Project number: S14045  
Letter reference: S14045LT2

**UNSW Kensington Campus Noise, Vibration and EMI from Light Rail  
Review of SLR Modification**

Table 1 Summary of “Modification 4” Review Comments

Figure 1 Proposed Relocated Light Rail Location

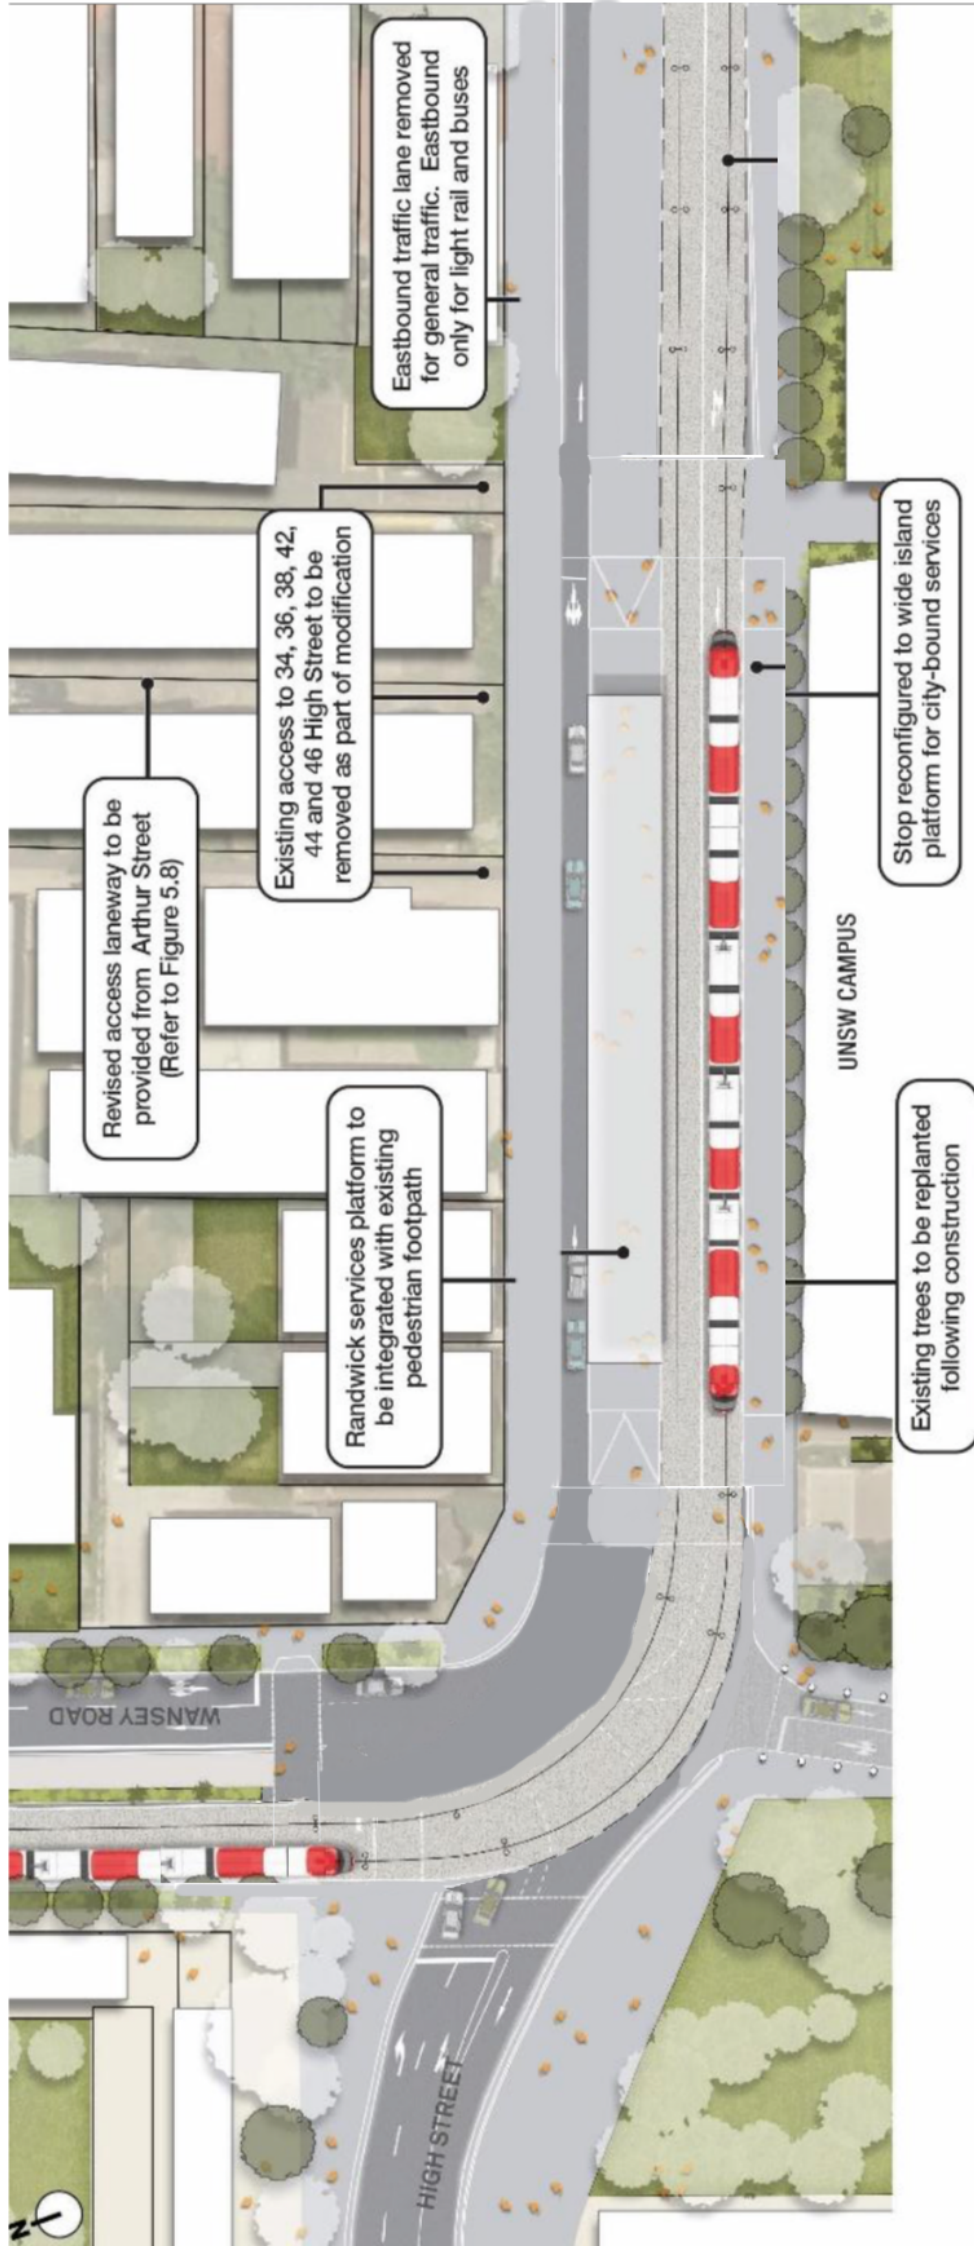
The location of the High Street stop is to be moved away from UNSW as part of this proposed modification as shown in the Figure 1.

Point	Management Plan (section and relevant text)	Response
1	CSELR Main Report General	<p>The key features relevant to the UNSW in this modification (from a vibration, noise and EMI perspective) are:</p> <ul style="list-style-type: none"> <li>• Tram track moved further away from the Lowy Building</li> <li>• Likely reduction of noise, vibration and EMI from the proposed Light Rail</li> </ul> <p>While there is some mention of the UNSW there is no specific consideration of Approval Conditions B17 and B18. This needs to be addressed (in a separate document) so that UNSW specific concerns are mitigated to a suitable level.</p> <p>While the Lowy Building is stated to be sensitive, the Wallace Wurth Building is also sensitive and should be addressed. This aspect is particularly critical for sensitive equipment such as Electron Microscopes and/or Animal Research Facilities.</p>

Point	Management Plan (section and relevant text)	Response
2	CSELR Main Report Table 3.1	The main report notes (page 24) that the proposal benefits include <i>“potentially reduced conflict between the light rail and sensitive equipment utilised by the UNSW, in particular the Lowy Cancer Research Centre”</i>  We agree that this comment is correct. It has however not been shown that there is no conflict.
3	CSELR Main Report Section 5.10	Electromagnetic Interference is considered in some detail in this section. However, it is not clear what mitigation is required and what performance standards are to be met at UNSW. This is subject to additional review as outlined in MCoA B17 and B18.
4	CSELR Appendix C Noise and Vibration Impact	The Noise & Vibration impact report does not address or reference MCoA B17 and B18. These conditions are yet to be assessed and satisfied.
5	Vibration	Mitigation and controls for impacts on UNSW to be assessed.
